Our Case Number: ABP-316212-23

Re: Proposed development of 26 wind turbines and associated works
at the Ballivor Bog Group, County Meath and County Westmeath

Re: The construction of 26 No. wind turbines and all associated hard-standing areas with the following parameters: a. A total blade tip height of 200m, b. Hub height of 115 metres, and c. Rotor diameter of 170 metres. ii. 2 No. permanent Meteorological Anemometry Masts with a height of 115 metres and associated hardstanding area and removal of existing meteorological mast. iii. 4 No. temporary construction compounds with temporary site offices and staff facilities, in the townlands of Bracklin and Grange More. iv. 5 No. temporary security cabins at the main construction site entrances and access points around the site, in the townlands of Killagh, Grange More and Coolronan. v. 2 No. borrow pits located in the townland of Grange More and Craddanstown and all works associated with the opening, gravel and spoil extraction, and decommissioning of the borrow pits. vi. 1 No. permanent 110 kV electrical substation, which will be constructed in the townland of Grange More. The electrical substation will have 2 No. single storey cont

Figure 13-17 Location of Hill of Tara and Frewin Hill in the LVIA Study Area

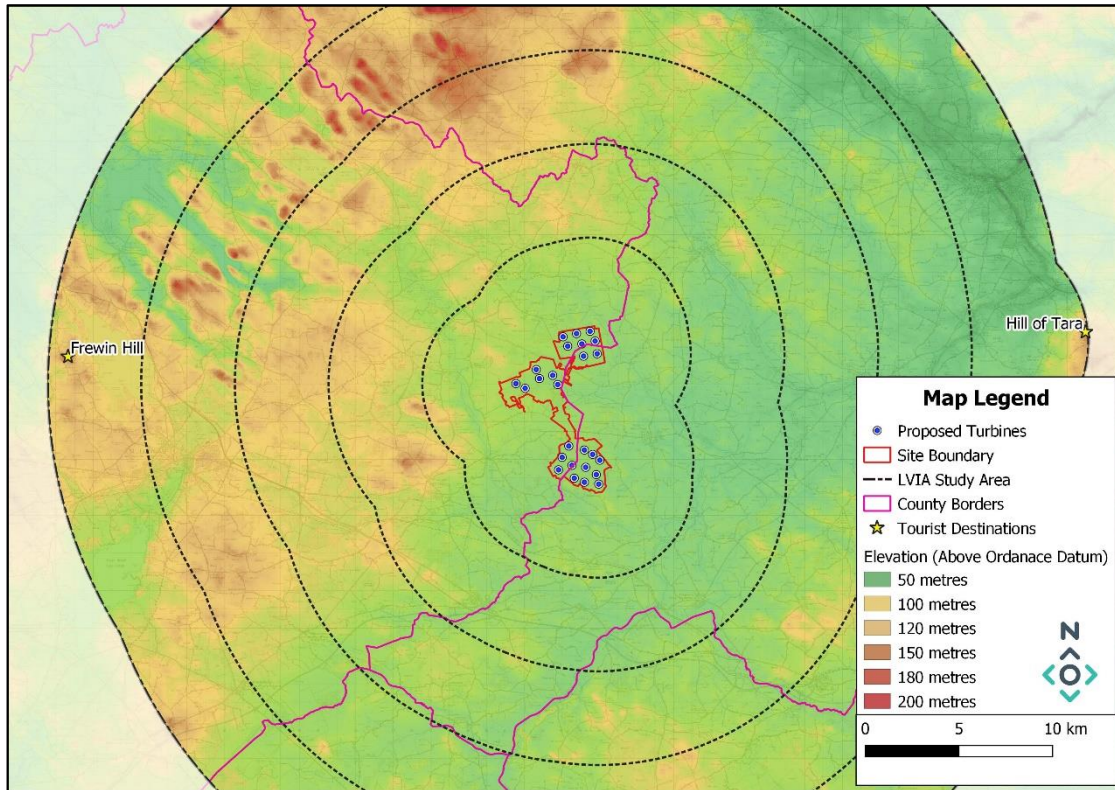
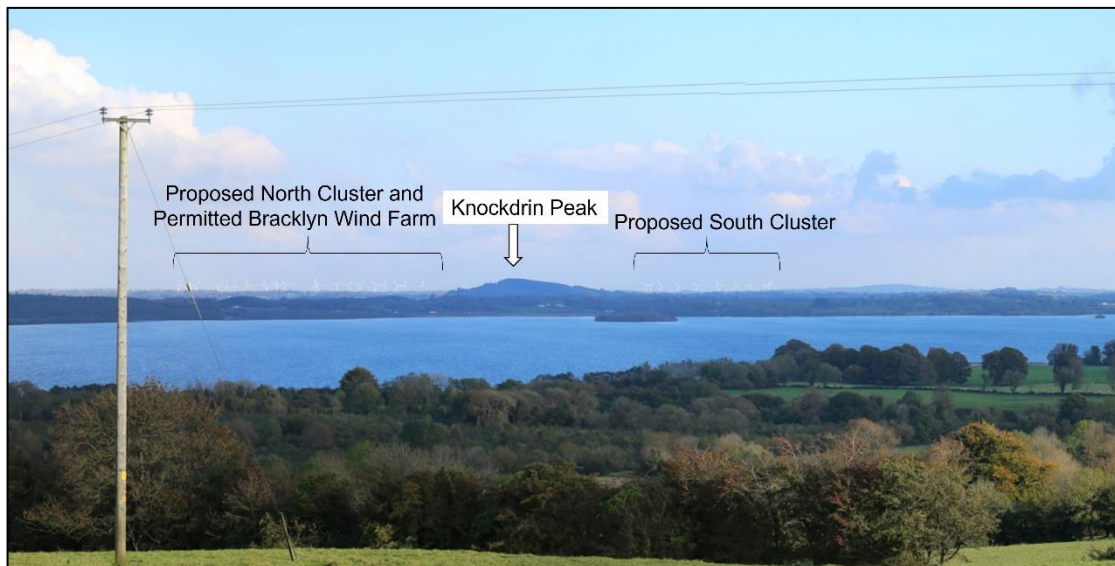
The OPW has concerns that the development, as proposed, may have a negative visual impact on the setting of, significance of, and the views from, and to, the following National Monuments: Hill of Tara, Loughcrew/Slieve na Calliagh, Trim Castle, Delvin Castle, Donore Castle, Frewin Hill and Raharney Ringfort. The OPW is very concerned about the impact on the O.U.V. (Outstanding Universal Value) of the Hill of Tara.

Based on Photomontage VP.02, the OPW is concerned that the 26no. 200m high plus 9 no. 185m high turbines, the latter already permitted, will feature prominently as very large manmade objects in the views to the west of the Hill of Tara. Being manmade objects, white and rotating, they will draw the eye and become the focus of that view. Their other effect is to alter the perceived scale of the landscape.

The planning application does not refer to World Heritage Tentative List status or proposed OUV detail; nor does it employ the tools provided by *UNESCO Guidance and Toolkit for Impact Assessments in a World Heritage Context* or the tool *UNESCO Guidance for Wind Energy Projects in a World Heritage Context* to assess the impact of the windfarm on the WH Tentative List property. The OPW recommends that these tools are employed in relation to the potential impact on the Hill of Tara.

From the application: 'A recent study of prehistoric burial mounds in County Westmeath undertaken by Dr. David McGuinness (2012 and 2014) has added significantly to the understanding of these monuments and their potential inter-visibility with and relationship to other important ritual sites such as the Hill of Uisneach and the passage tombs of Loughcrew. ...This inter-visibility may be regarded as an important aspect of these monuments and their relationship with similar monuments and sites in the surrounding landscape.'

Referencing VP08, the EIS states: 'the Proposed Turbines are visible behind Lough Owel, in the background of the image and will not alter the character, immediate setting and appearance of the High Amenity Area. There will be a negligible magnitude of change to the character and setting of these receptors and no significant landscape effects will occur.' 'all turbines will be visible at a distance at various turbine heights.' In clear weather conditions: 'three turbines will be visible from approximately mid shaft upwards (T01 and T11-T12). Only the upper portions of the remaining turbines may be visible from the top of Frewin Hill.' 'effects may increase from Slight when considering Ballivor turbine alone to Slight/moderate when considering Ballivor and Bracklyn.'
